2.2 Consented Scheme Comparison Proposed Scheme - Second Floor

Bay A
Proposed Typical Bay Study - Porte Cochere

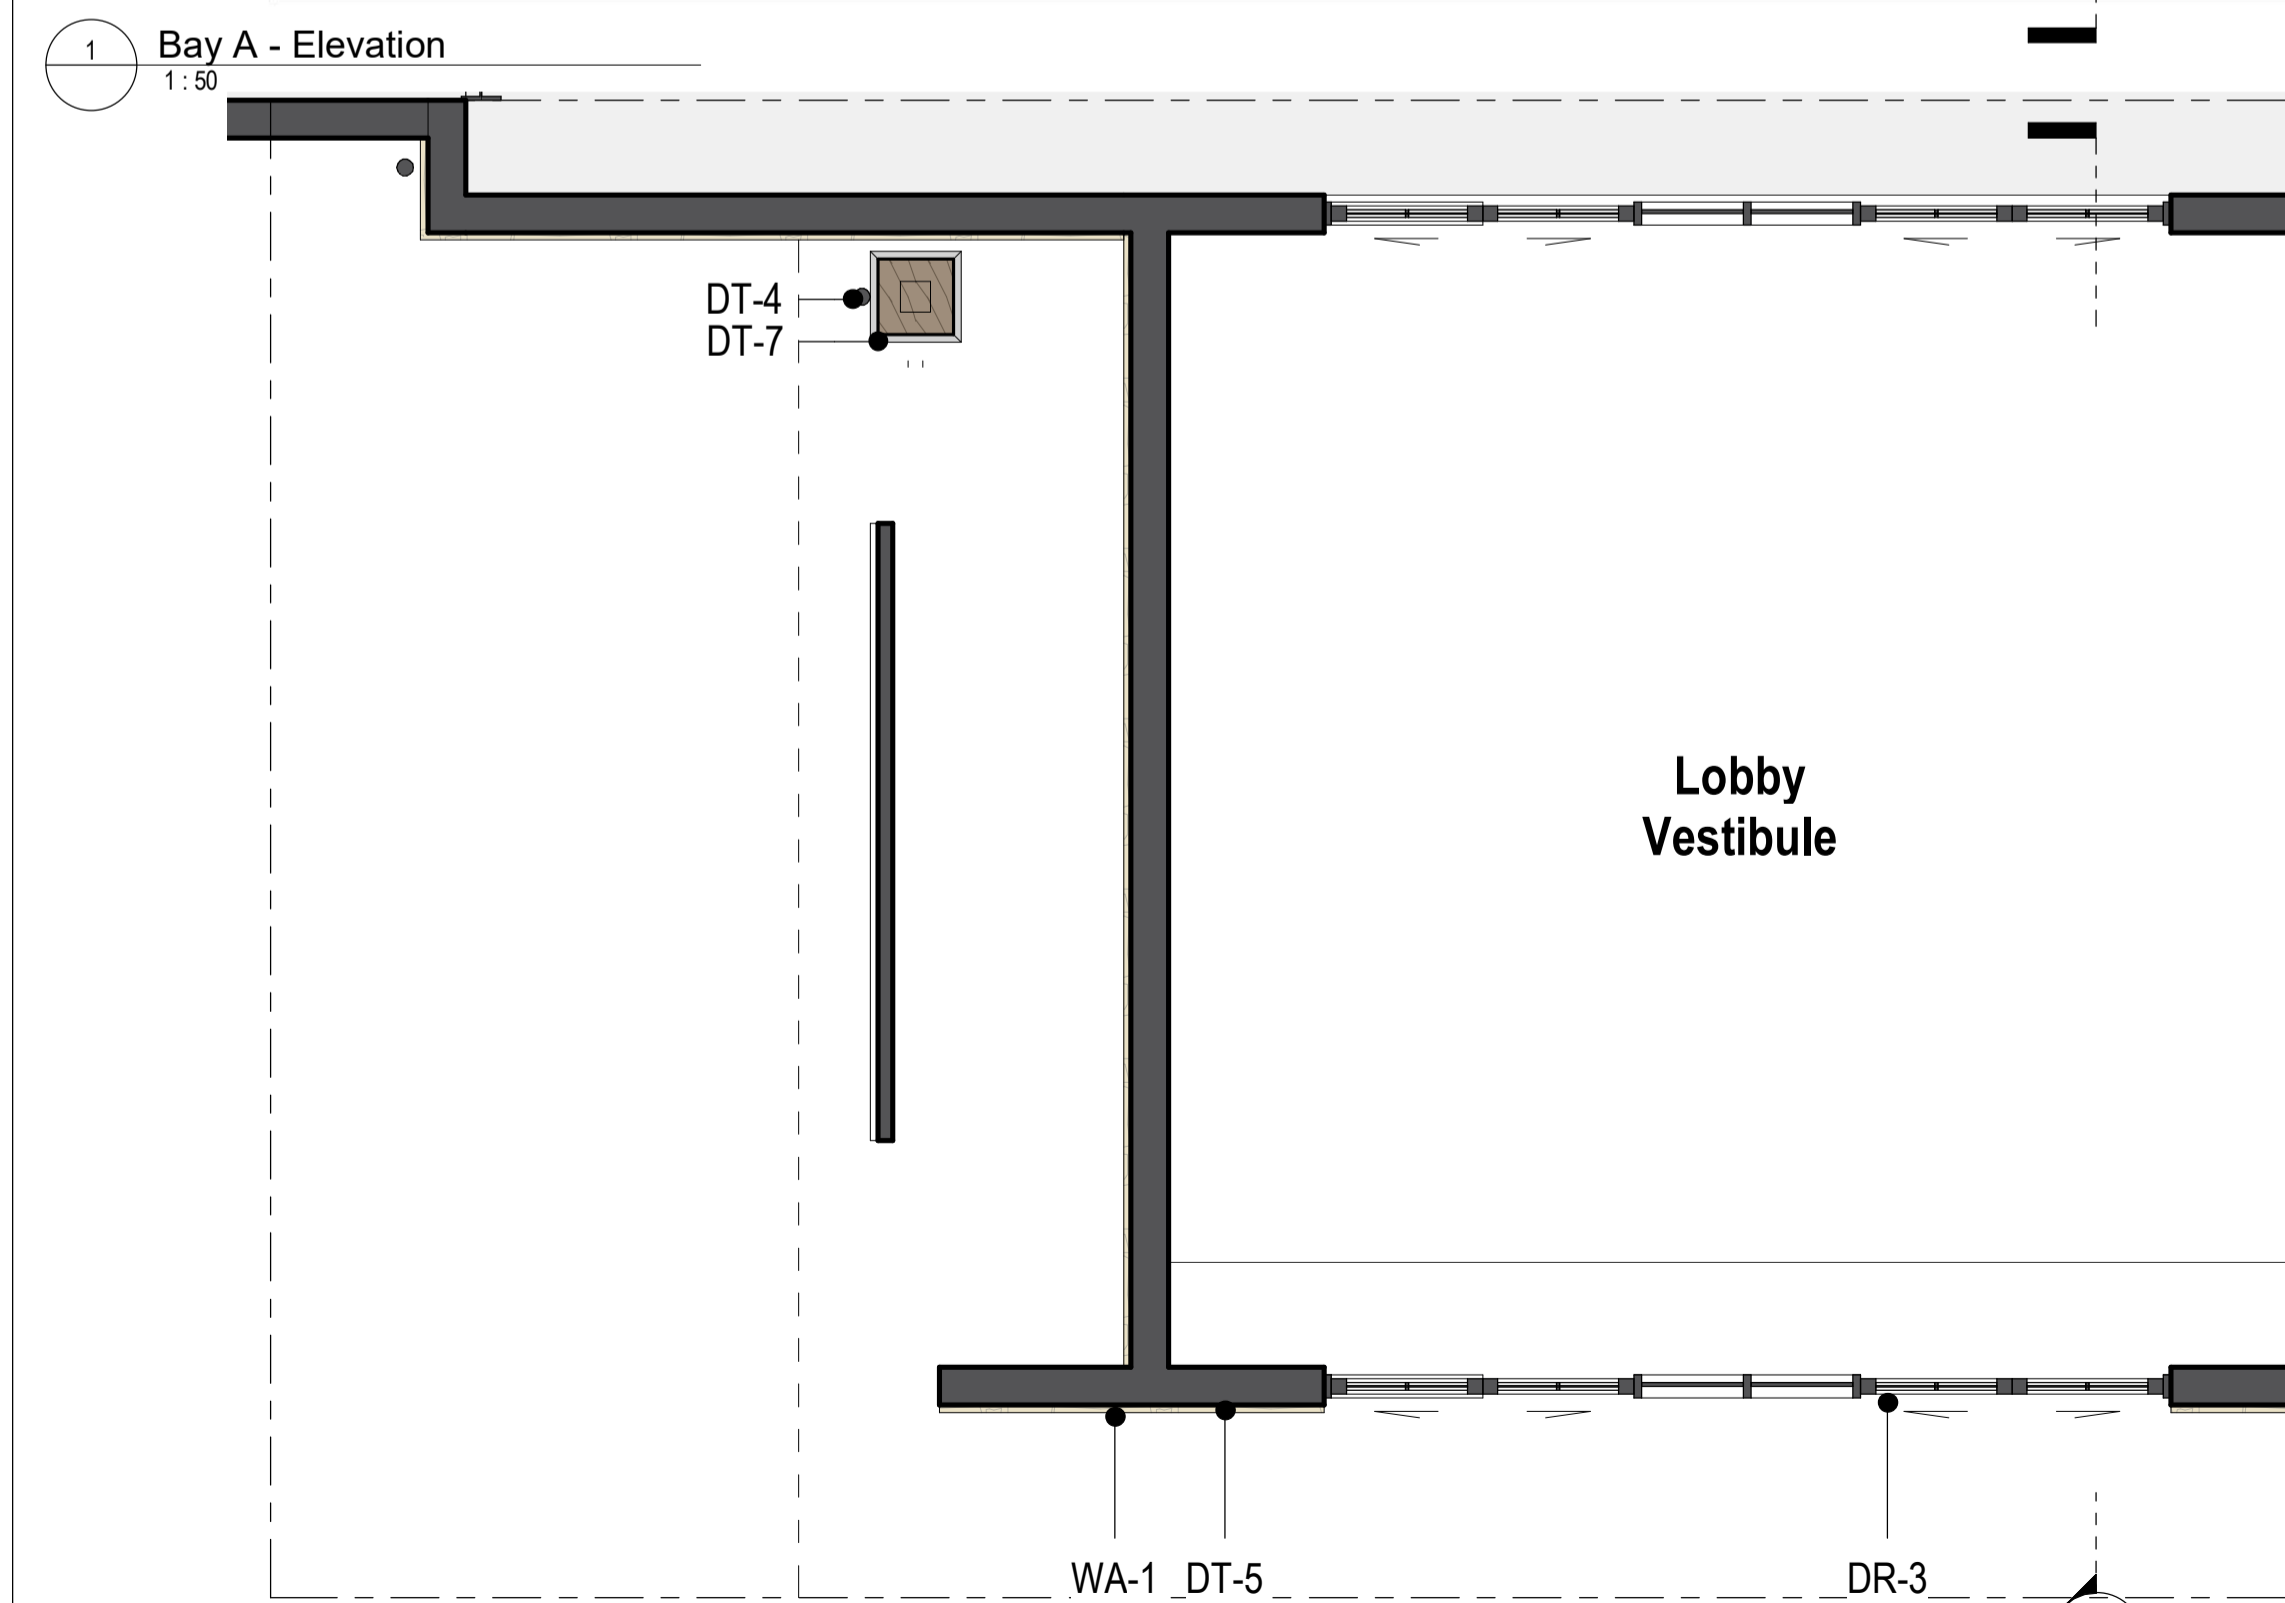
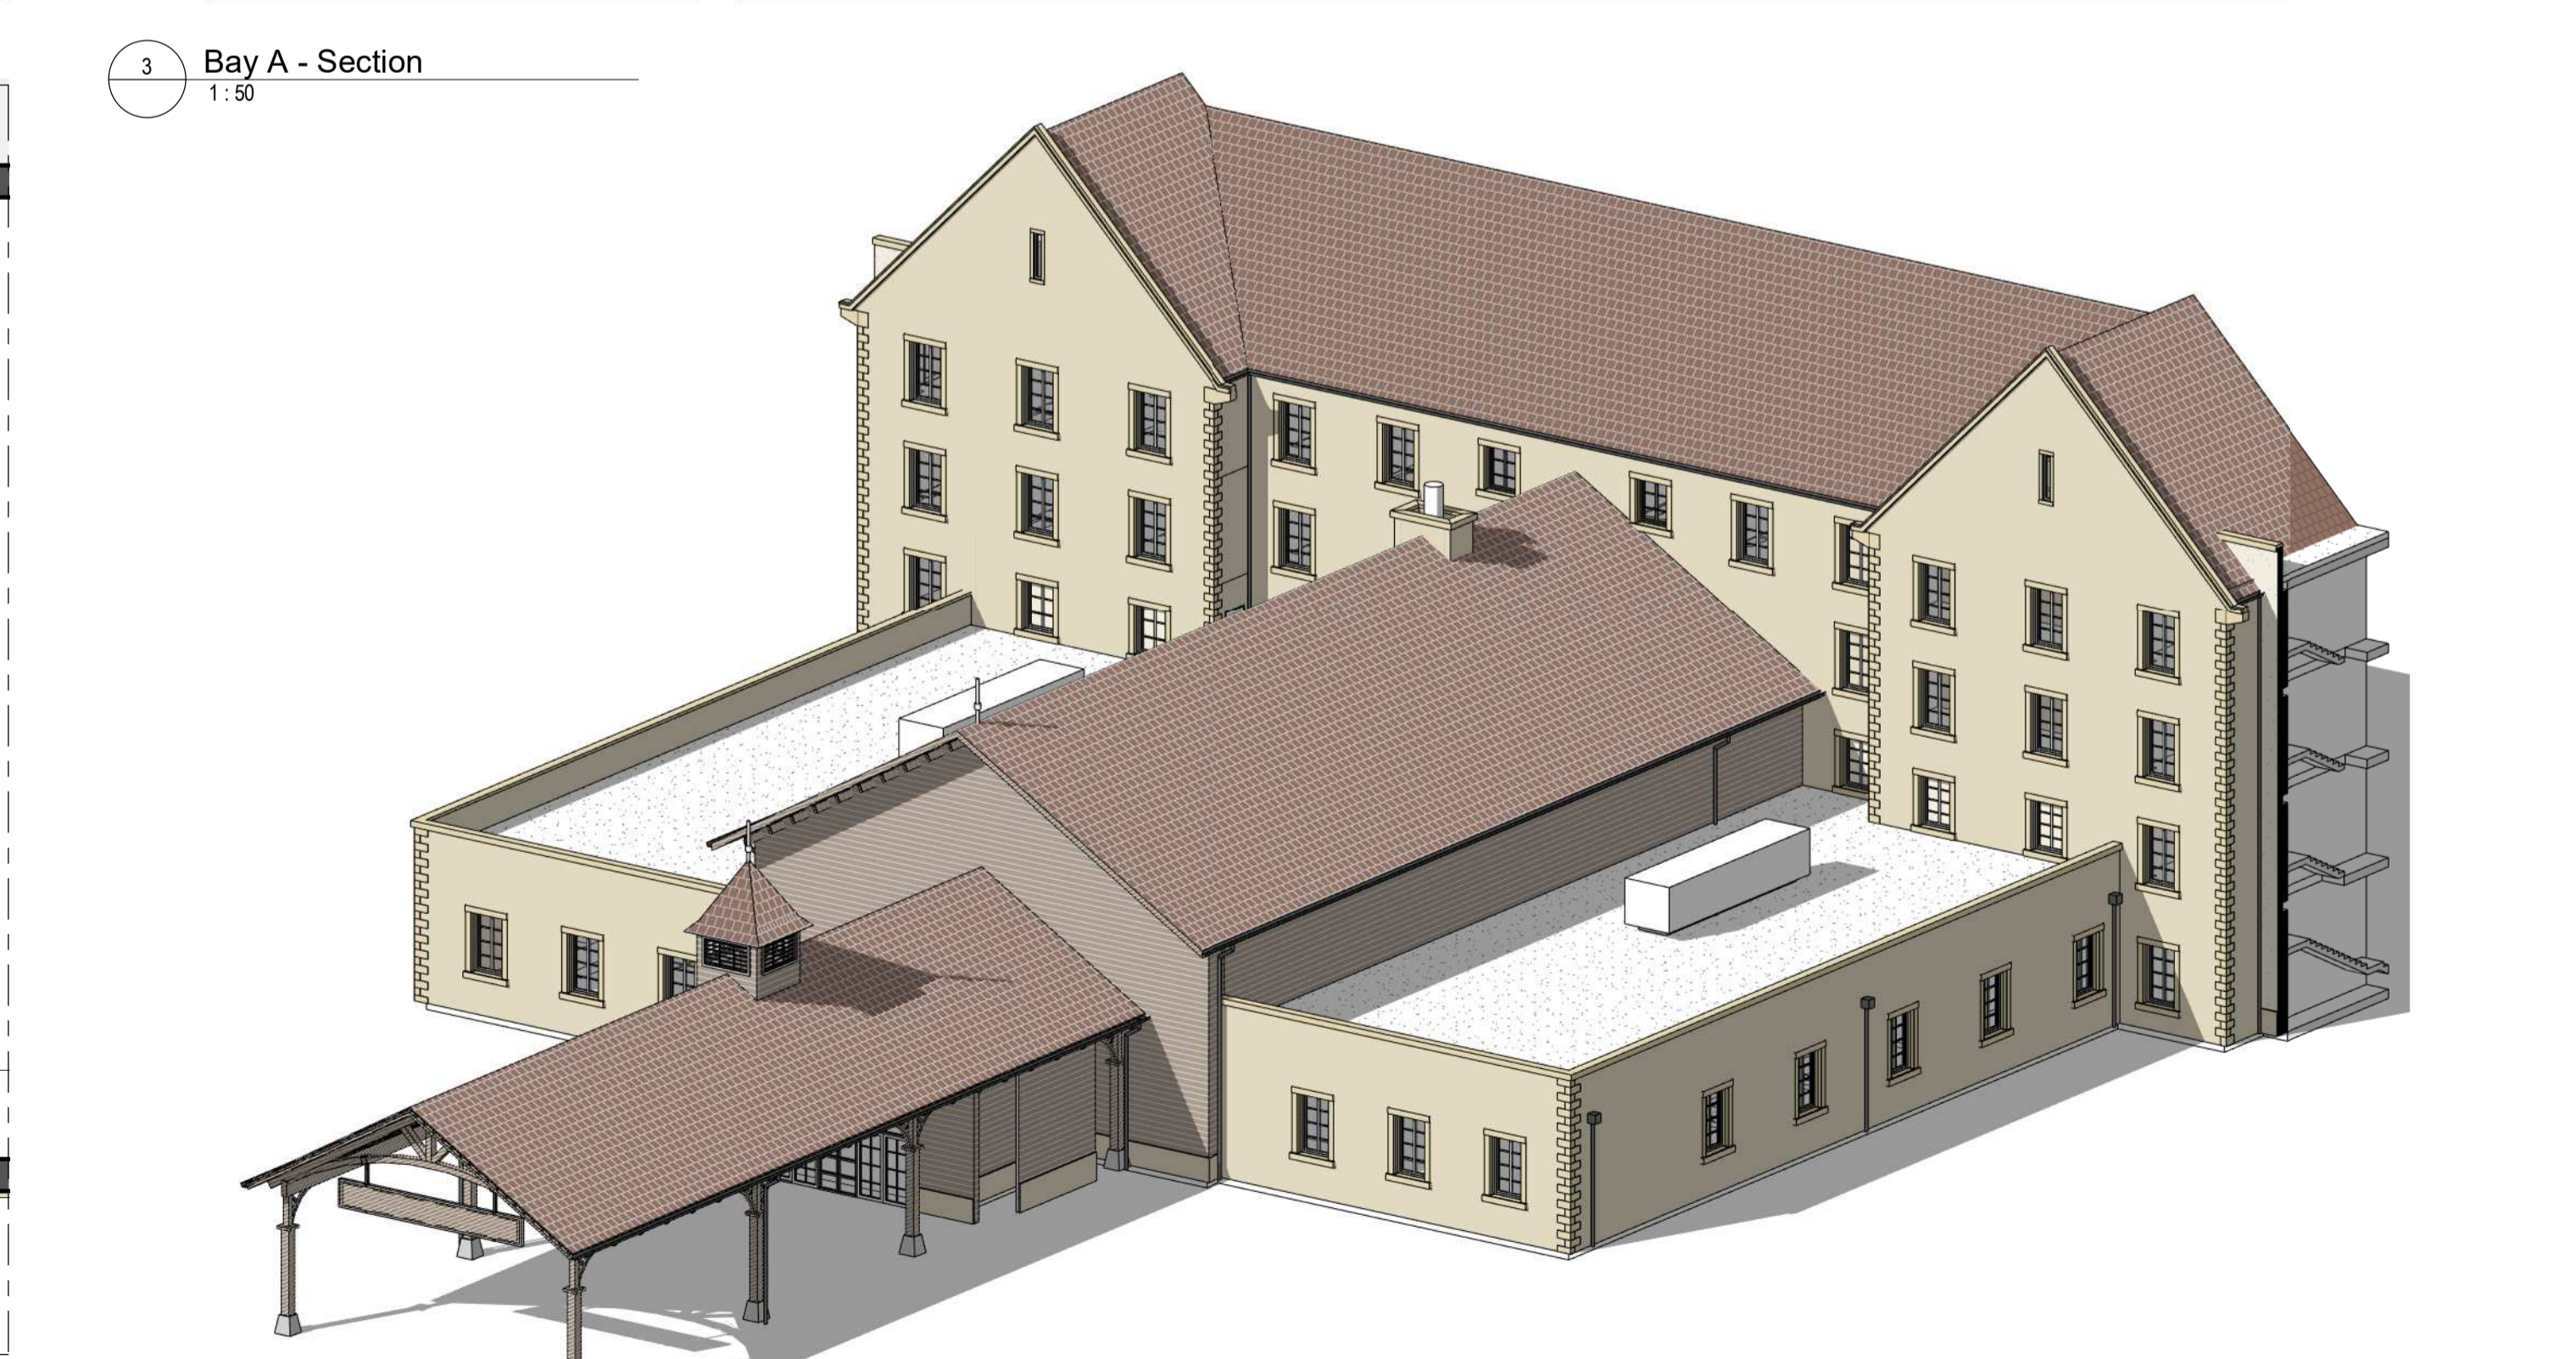
2.2 Consented Scheme Comparison Proposed Scheme - Porte Cochere

Extension of the Porte cochere as a result of shifting the building southwards 3.6m to allow for a larger drop off / set down point for arriving guest vehicles/buse.

- Introduction of 4 level drop off lanes and pedestrian zones.
- 3 lanes introduced within roundabout road way to split into 4 laned drop off.
